Rezoning Petition Review

Date of Review: May 20, 2020

Rezoning Petition #: 20-57

Location of Property: Approximately 92 acres located west of I-485, on the north side of Old Dowd Rd and east of Sam Wilson Rd.

Schematic Site Plan Rezoning Petition #2020-xxx

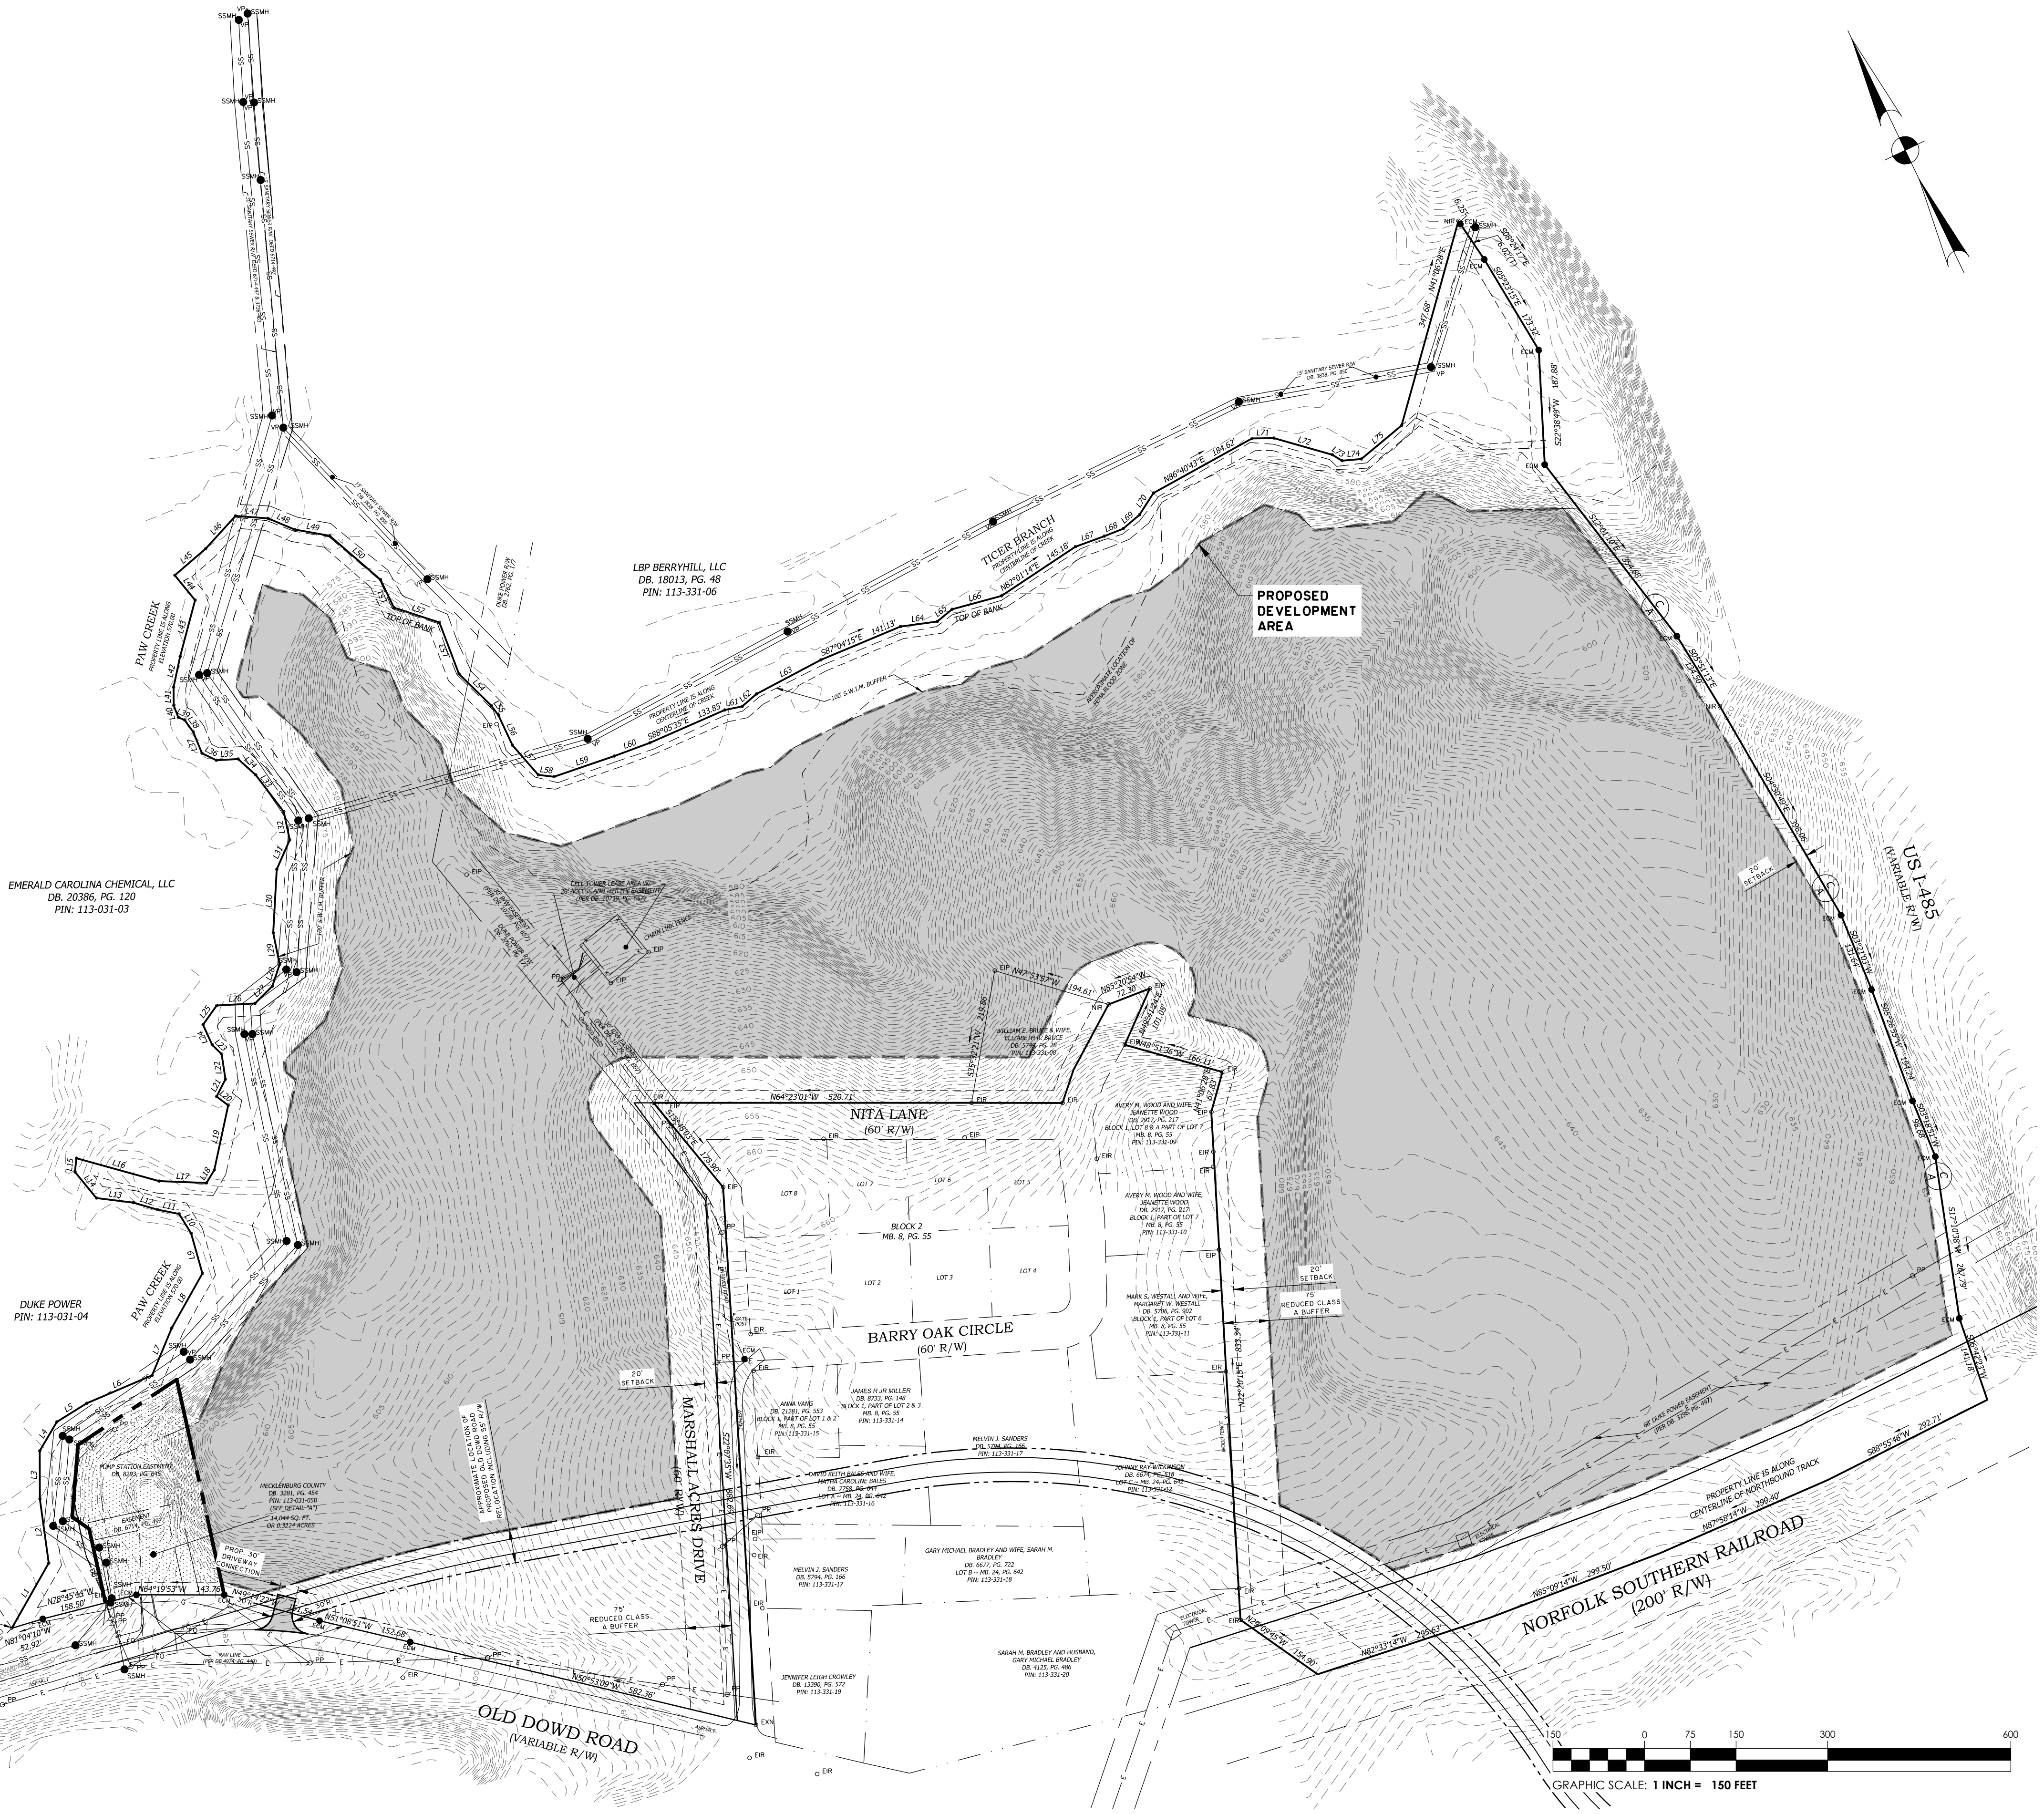
Concerning Storm Water: The rezoning plan sheet indicates a 100-ft SWIM Buffer on site. Please revise buffer label to read “100-ft SWIM/Watershed/PCSO Buffer.”

City GIS indicates a 30-PCSO buffer on the eastern portion of the proposed development and parallel to I-485. Please include the following note under *Environmental Features: Development within the SWIM/PCSO Buffer shall be coordinated with and subject to approval by Charlotte-Mecklenburg Storm Water Services and mitigated if required by City ordinance. Stream Delineation Reports are subject to review and approval by Charlotte Storm Water Services.*
